CITY & COUNTY OF SWANSEA

**POST HEARING –
WRITTEN SUBMISSION OF ORAL CASE**

Abergelli Power Project

**Issue Specific Hearing on the Draft Development Consent
Order (DCO)**

Figure 1 Hedgerow Survey Locations and Results

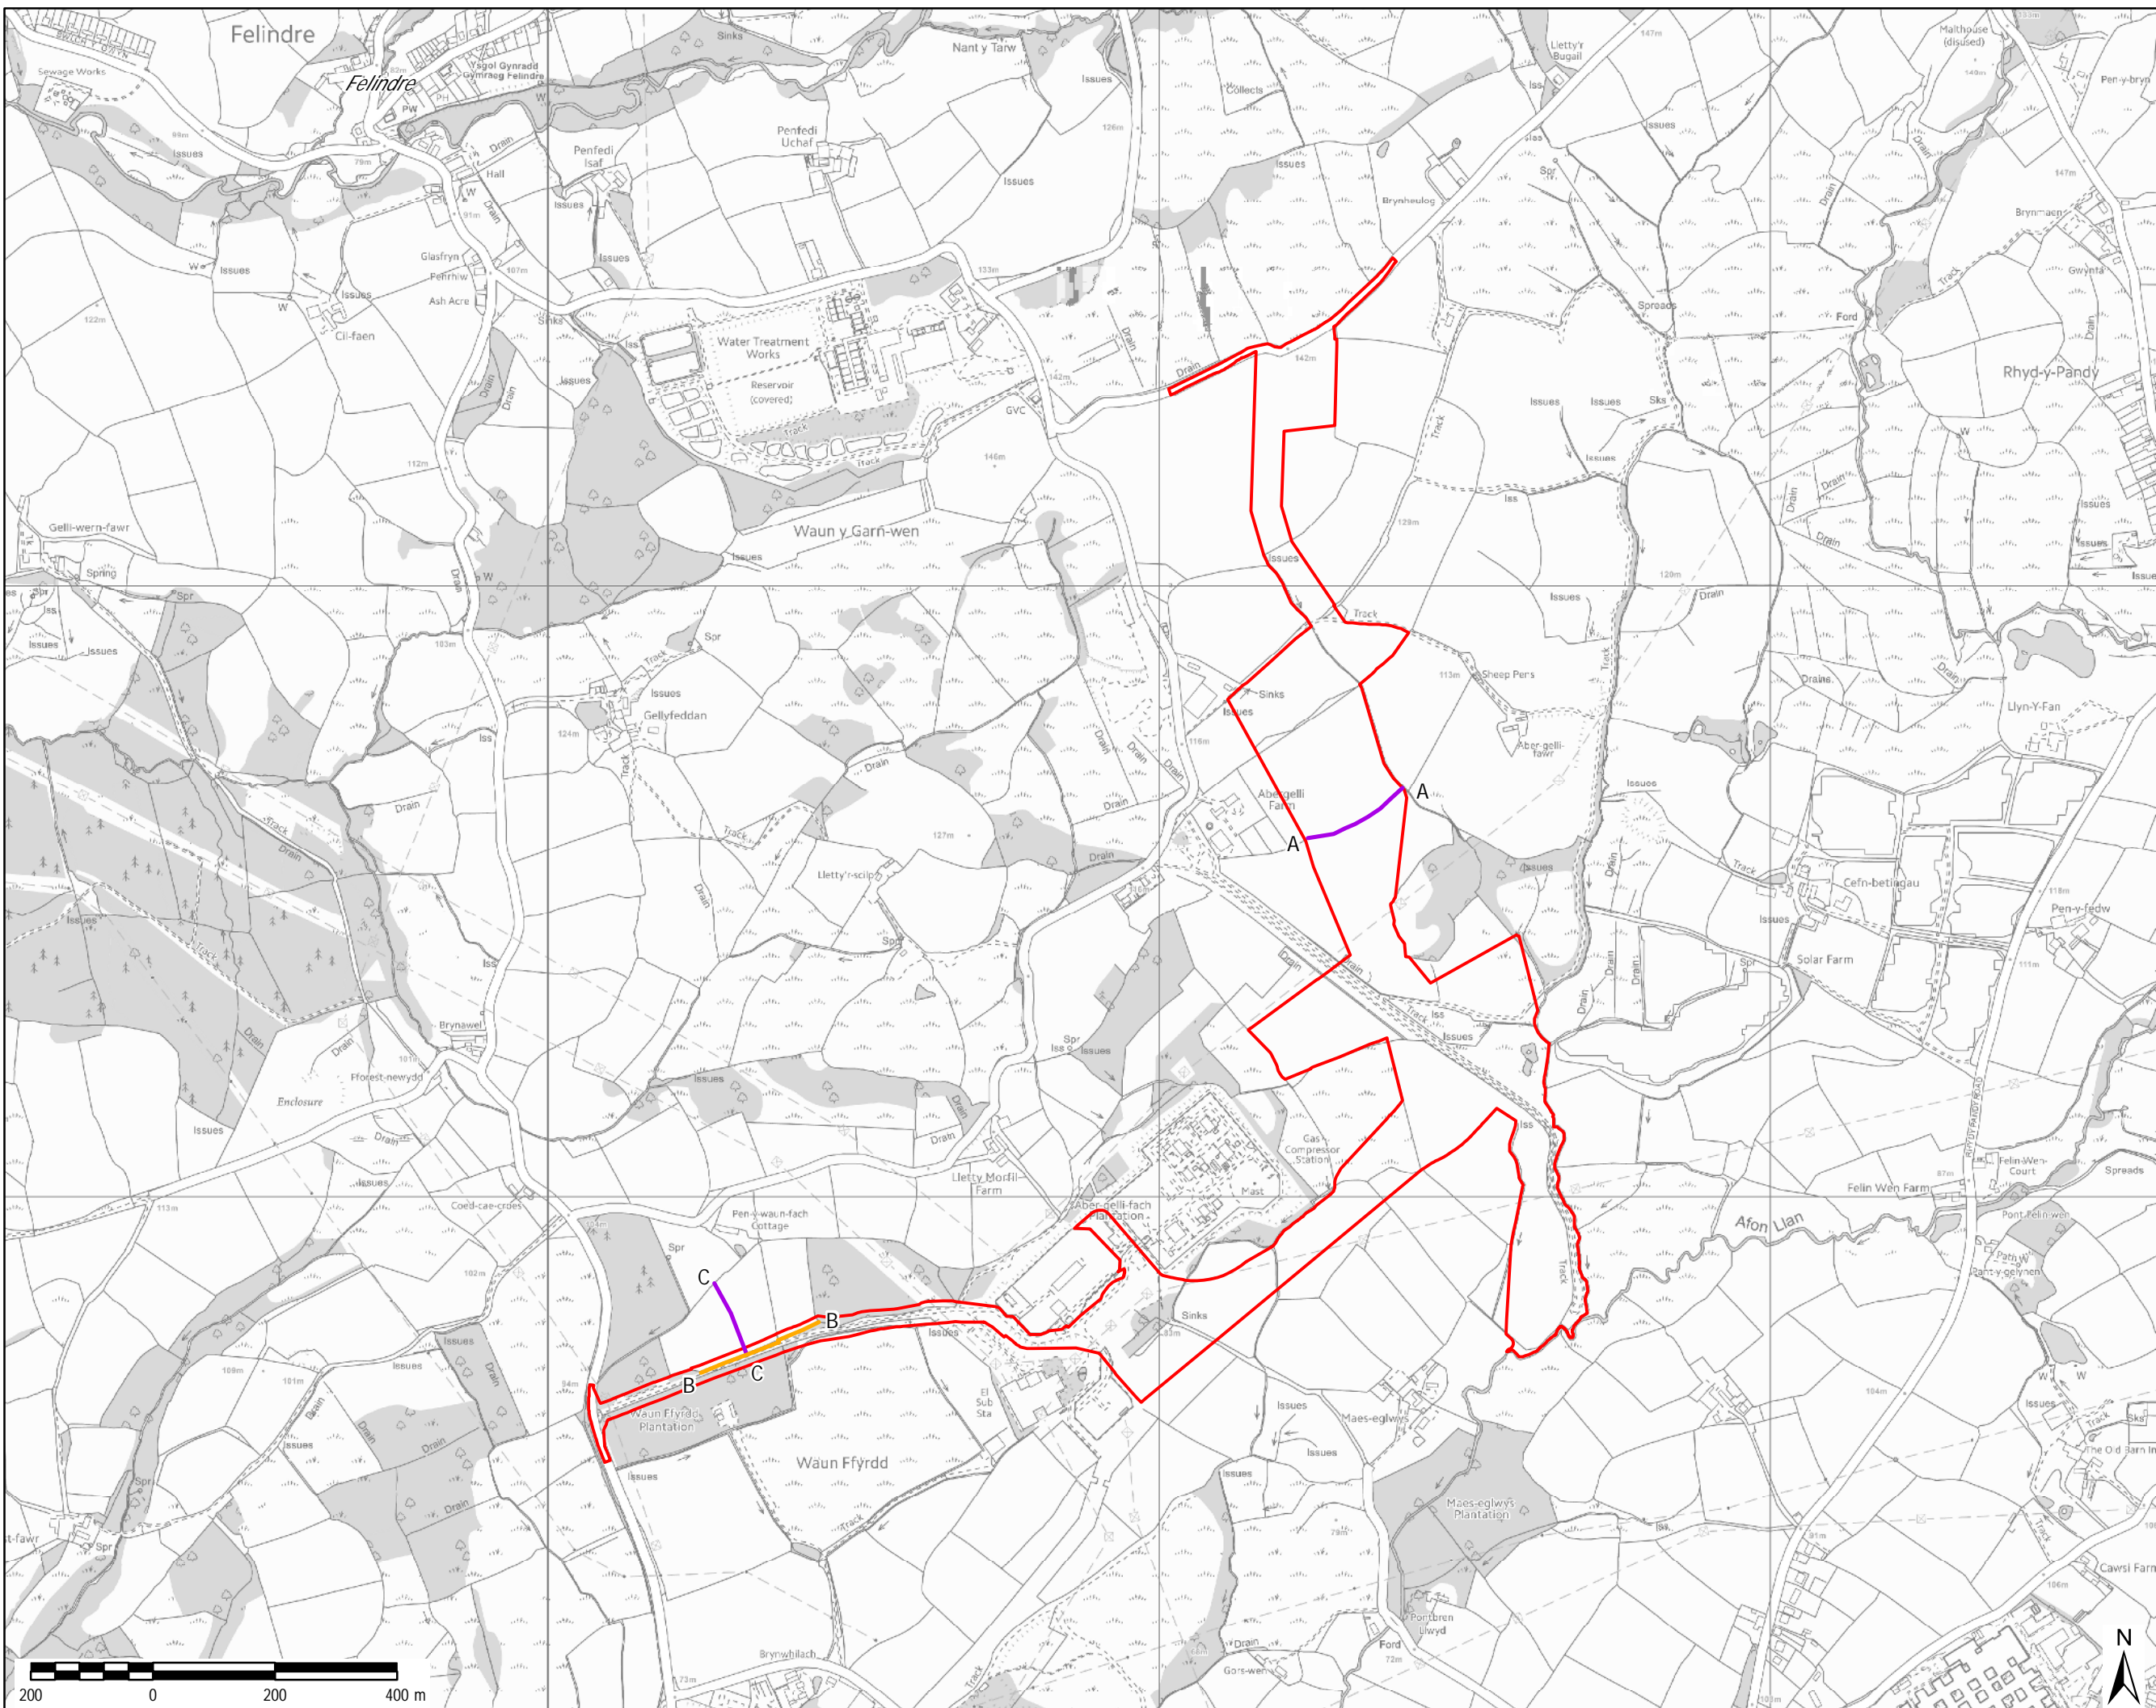
CCS queried whether S35(4) gave too much leeway to remove hedges and whether they would be outside of the limits included in the DCO.

Illustrative Elevation of Road Structure Over Utilities

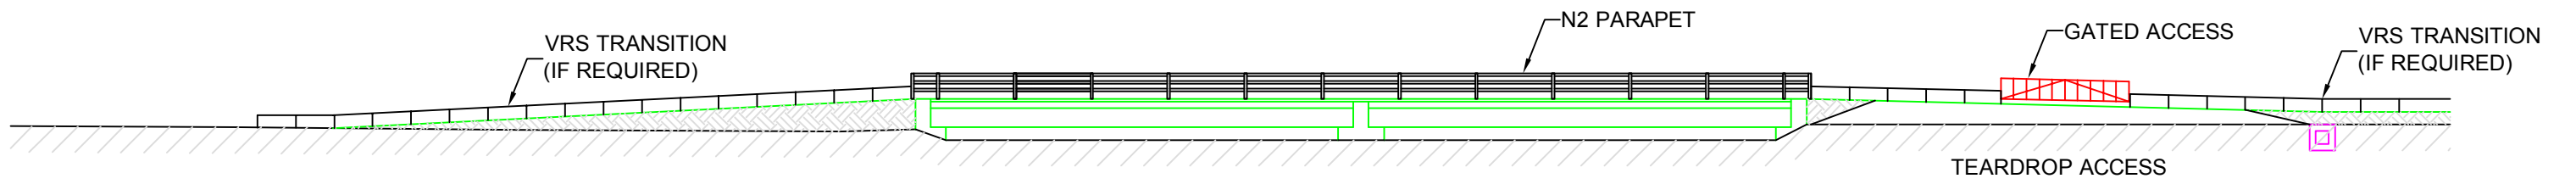
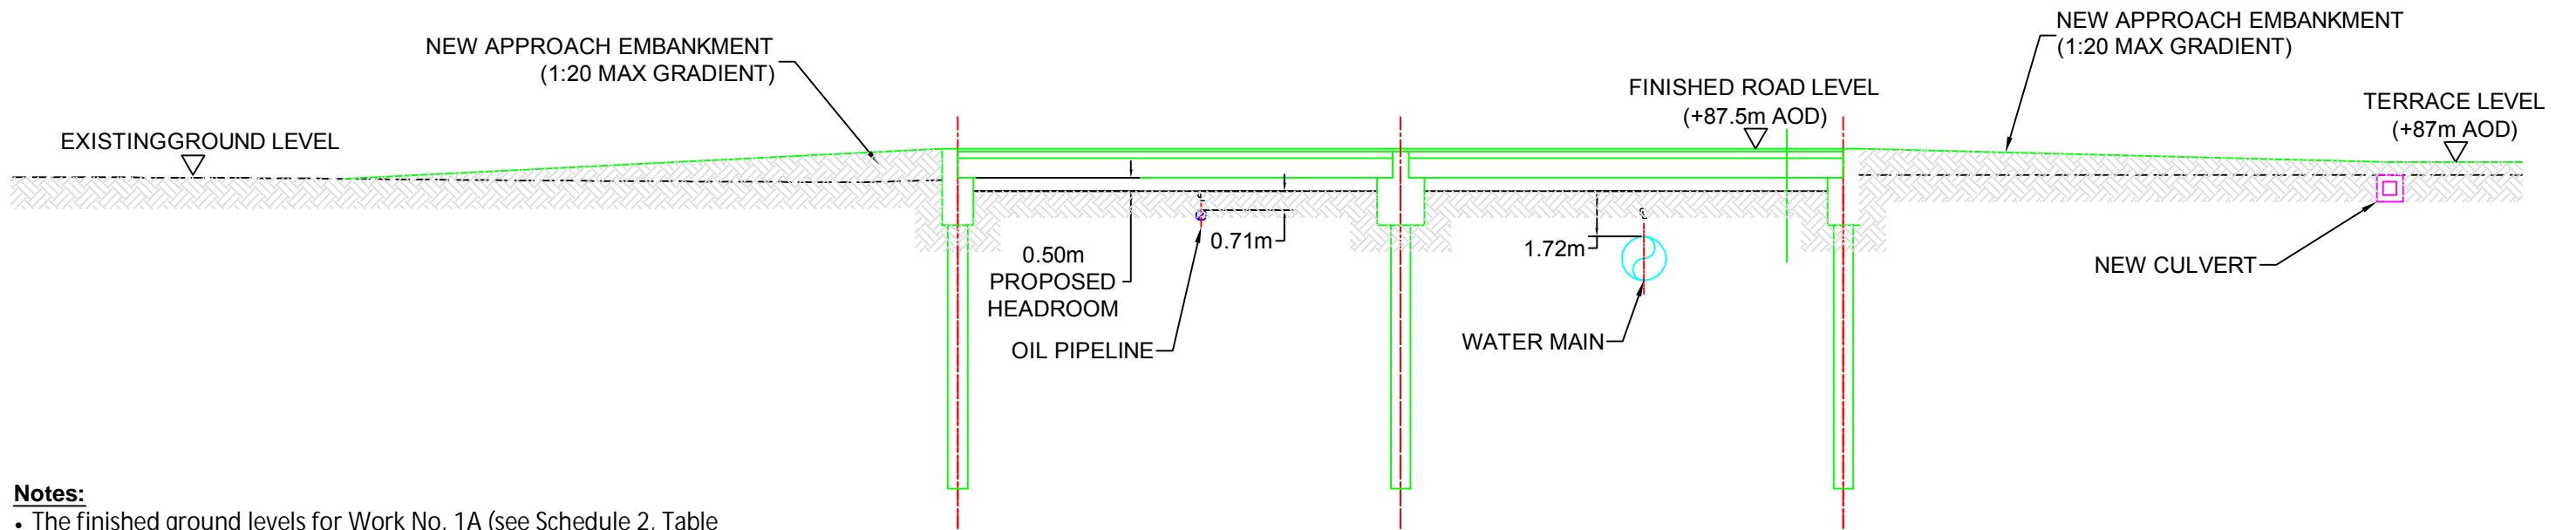
CCS had no comments at the current time but consider that the parameters should be included and CCS should be given the opportunity to comment on the details.
